From: Clare Dales
Sent: 27 March 2018 09:41
To: Anita Gardner
Subject: RE: 14 South Terrace - Plaster Revision

Re:- Planning Application LU/422/17/PL
And
Listed Building Application LU/423/17/L

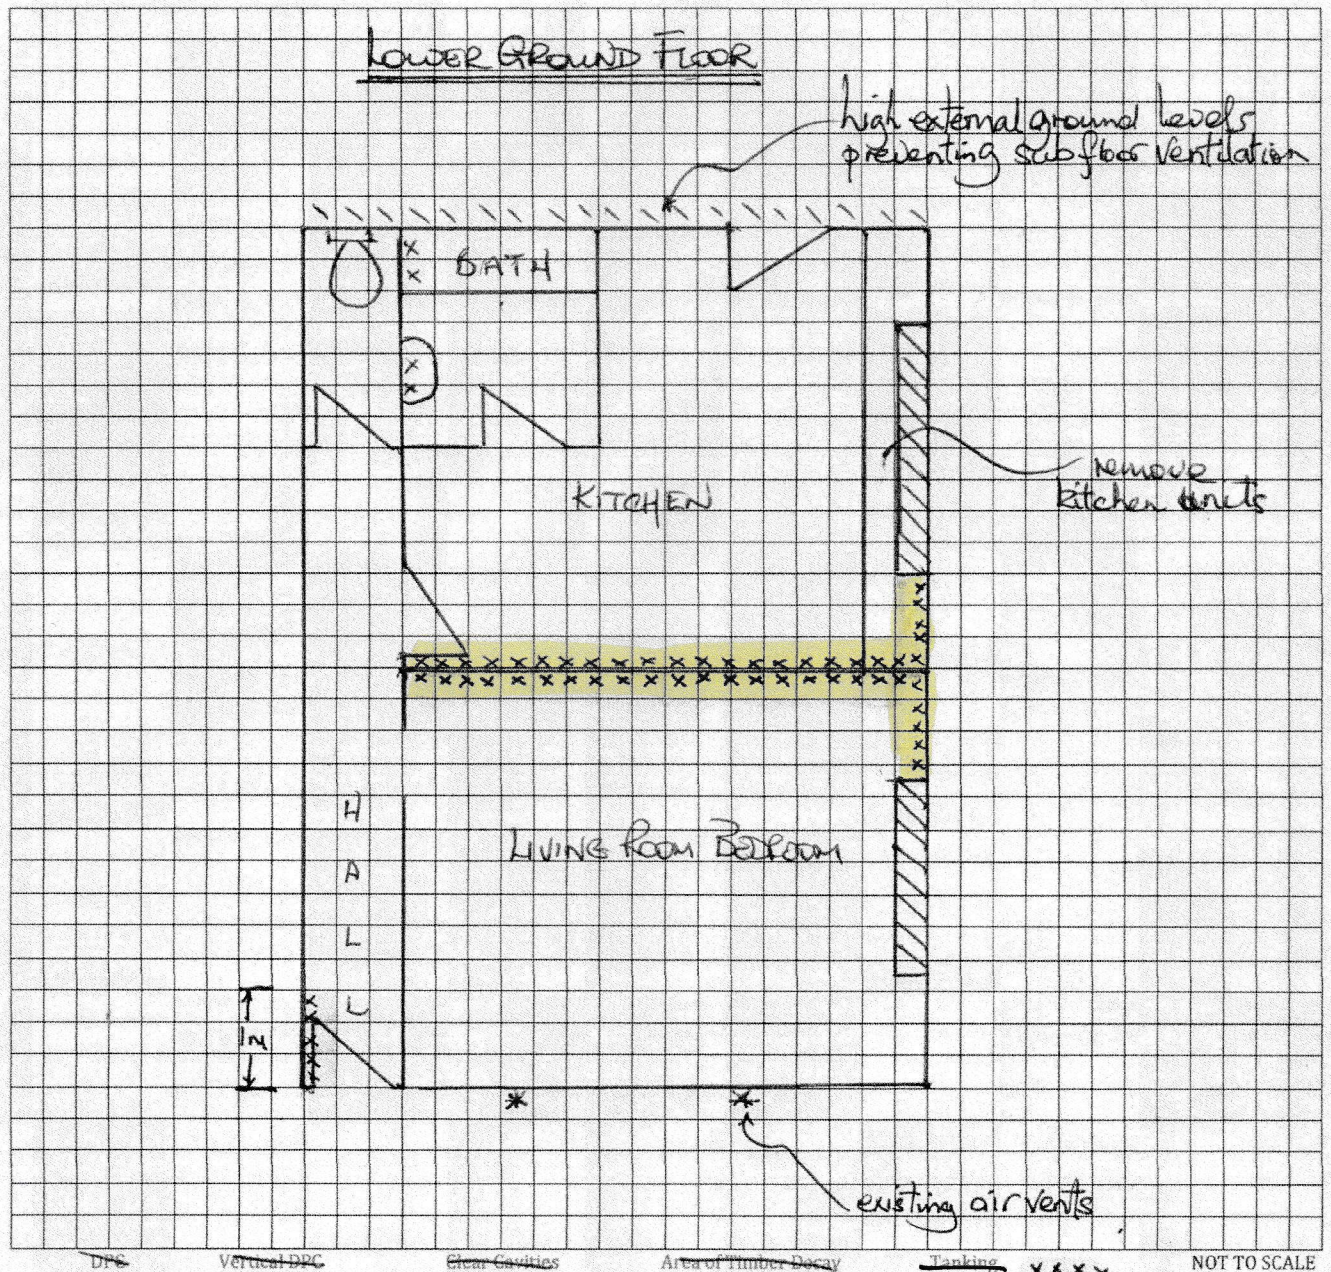
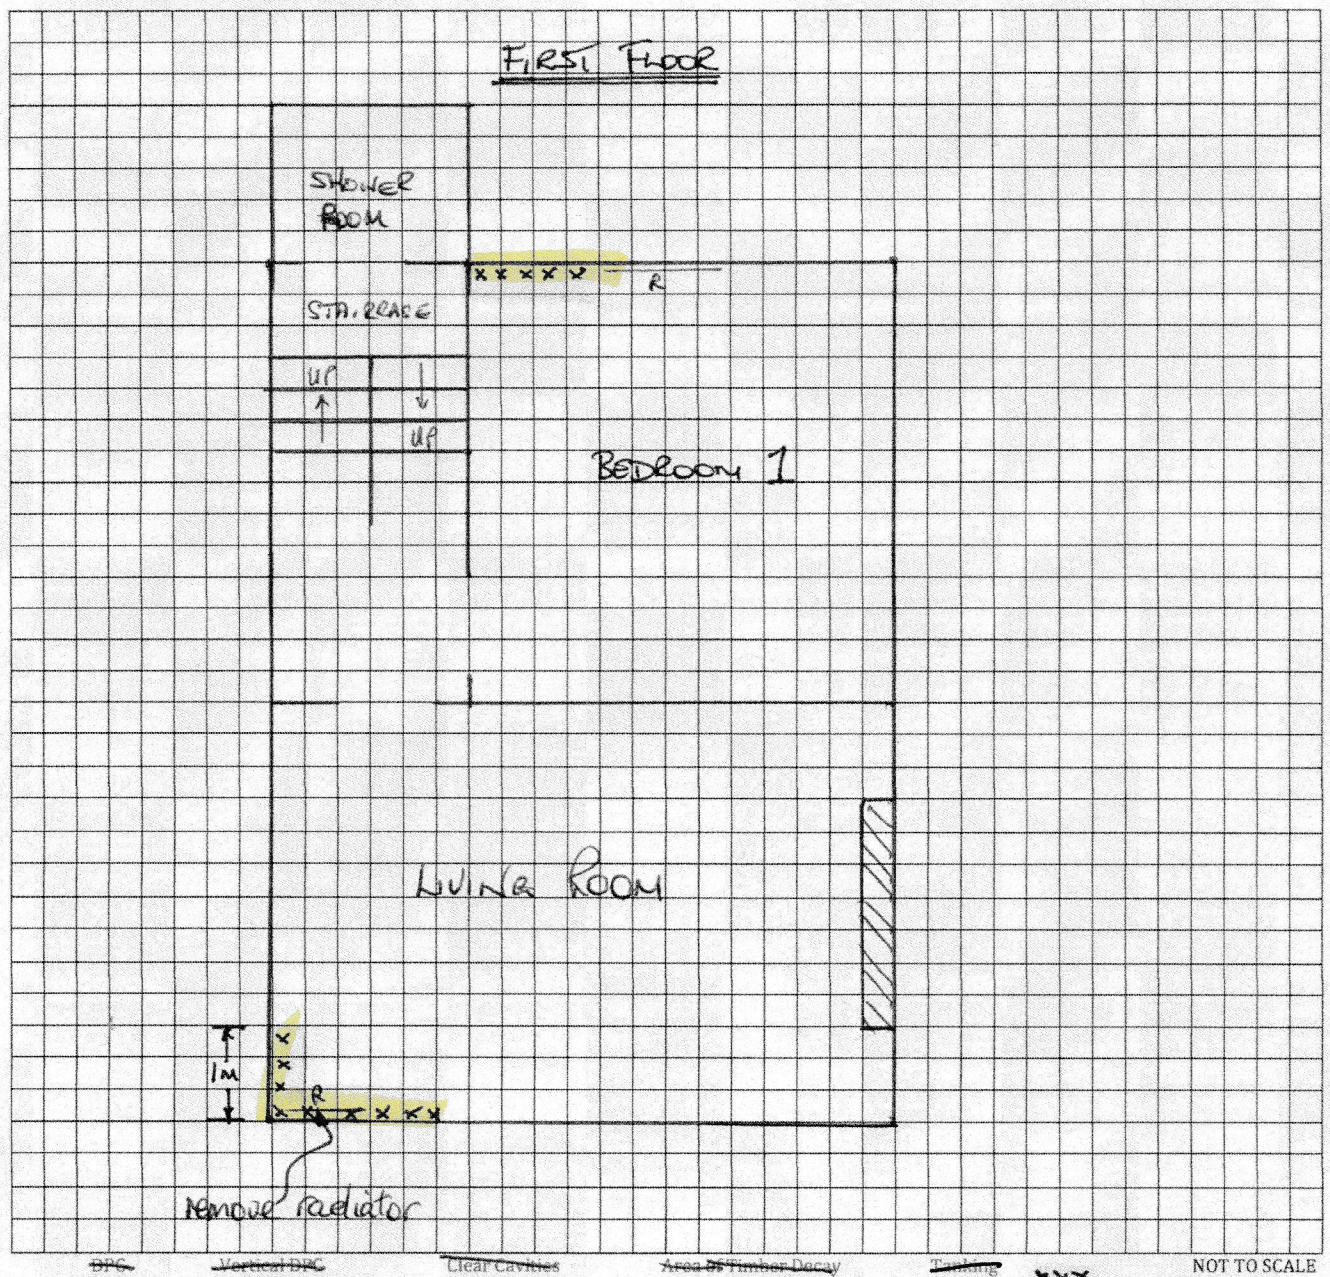
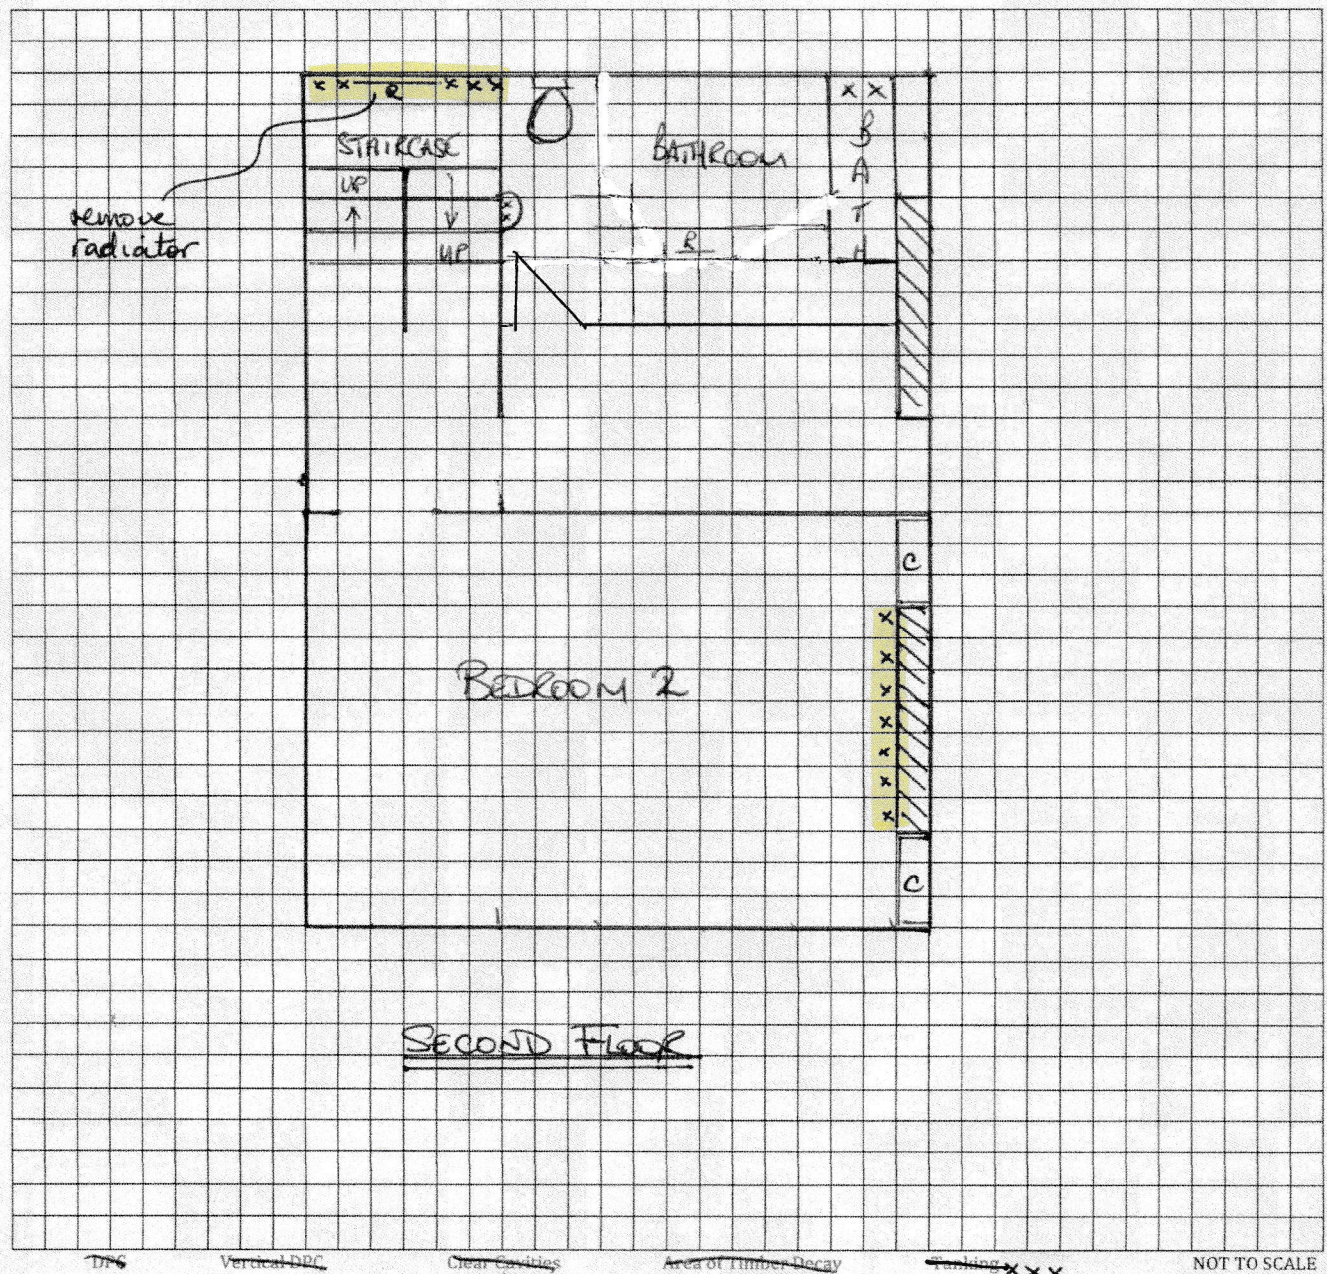
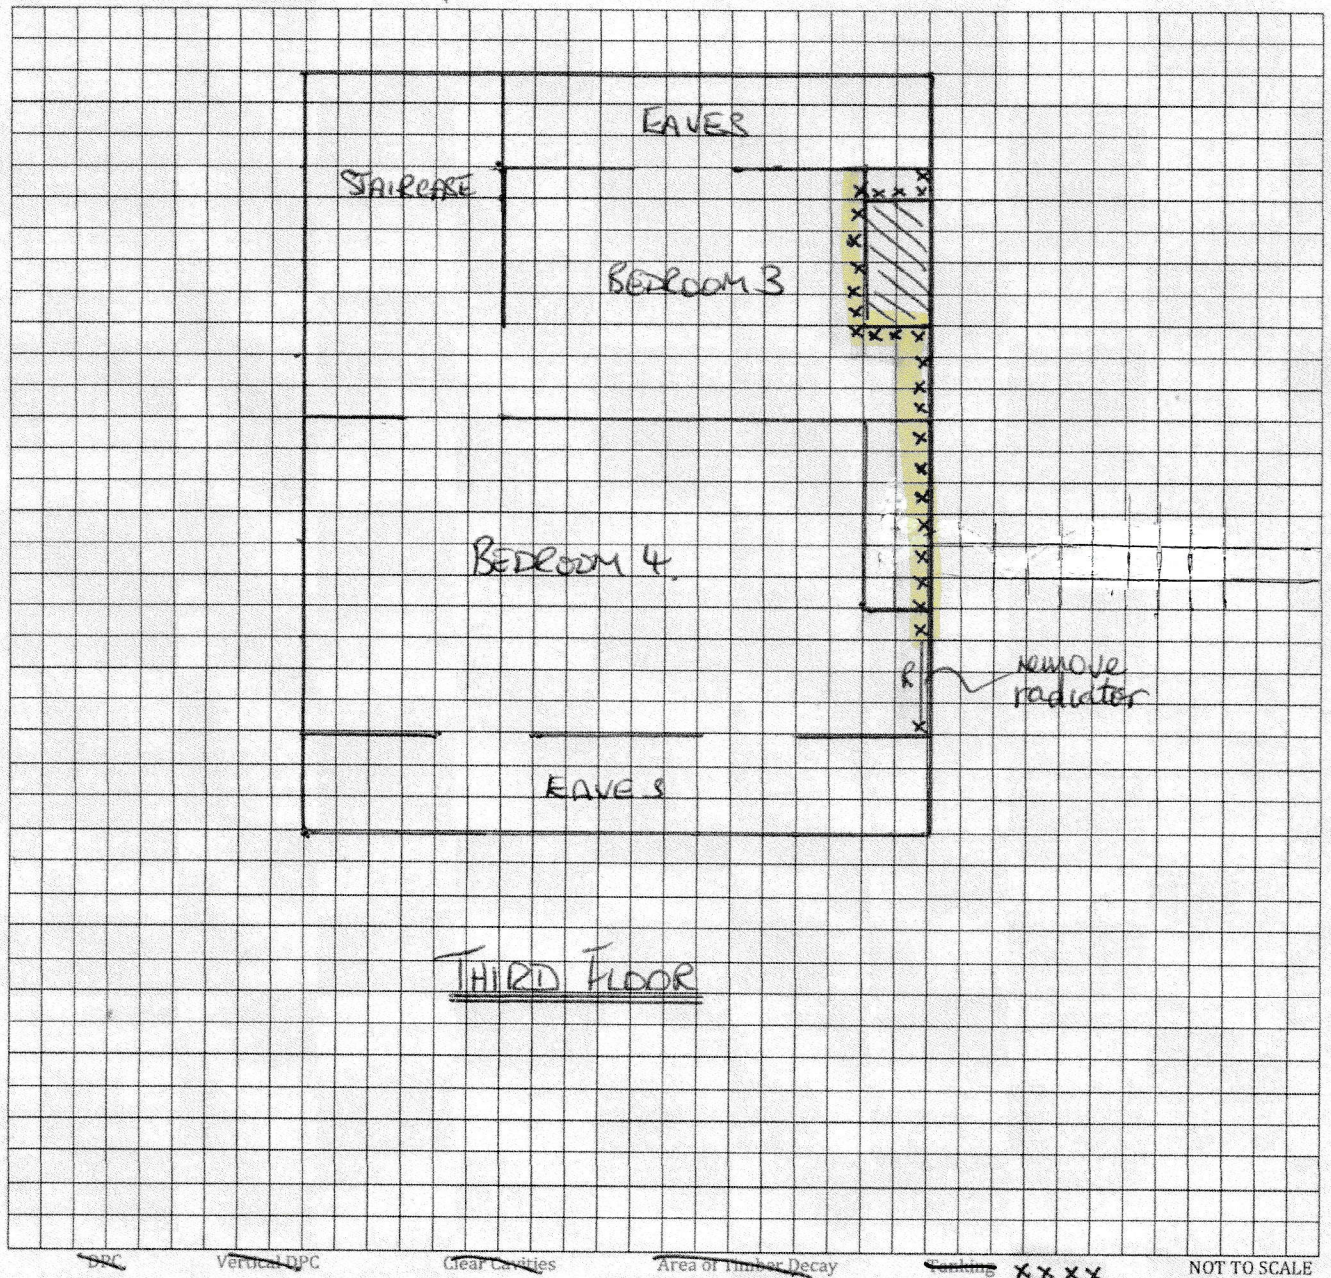
Thank you for forwarding the revised information regarding plaster to the above property. I can confirm that the application of lime plaster is proposed is considered suitable. Note that the existing cement plaster with its waterproofing should be removed prior to application of this plaster. The applicant cited water ingress from the roof and other defective areas has caused the damp, and they may wish/need to allow time for the building to dry/breathe. Note we are not authorising specific products.
